PROJECT SUMMARY: NEW METAL BUILDING TO EXISTING LOT

2018-016-FARICY
REC BUILDING
1875 MAIN ST.
COLORADO SPRINGS

Add PCD File No. AL1821

SITE PLAN  
PCD FILE NO: AL 1821

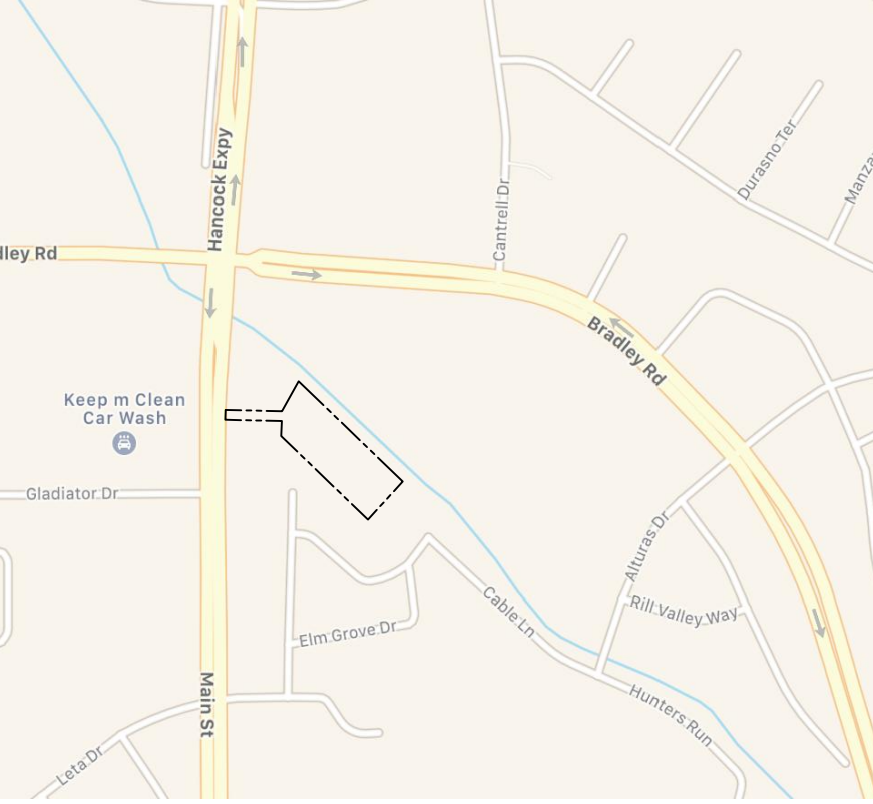
State what the scale is (i.e. 1"=30')

The existing asphalt drive aisle must also be included in the impervious area.

Add PCD File No. AL1821

Call out this easement with the book and page

Include a route from the handicap spots to the building and include this note:

The parties responsible for this plan have familiarized themselves with all current accessibility criteria and specifications and the proposed plan reflects all site elements required by the applicable ADA design standards and guidelines as published by the United States Department of Justice. Approval of this plan by El Paso County does not assure compliance with the ADA or any regulations or guidelines enacted or promulgated under or with respect to such laws.

a 15 foot buffer will be required for the site development plan application with 1 tree per 25 feet of common lot line with one of those 3 trees being an evergreen tree.
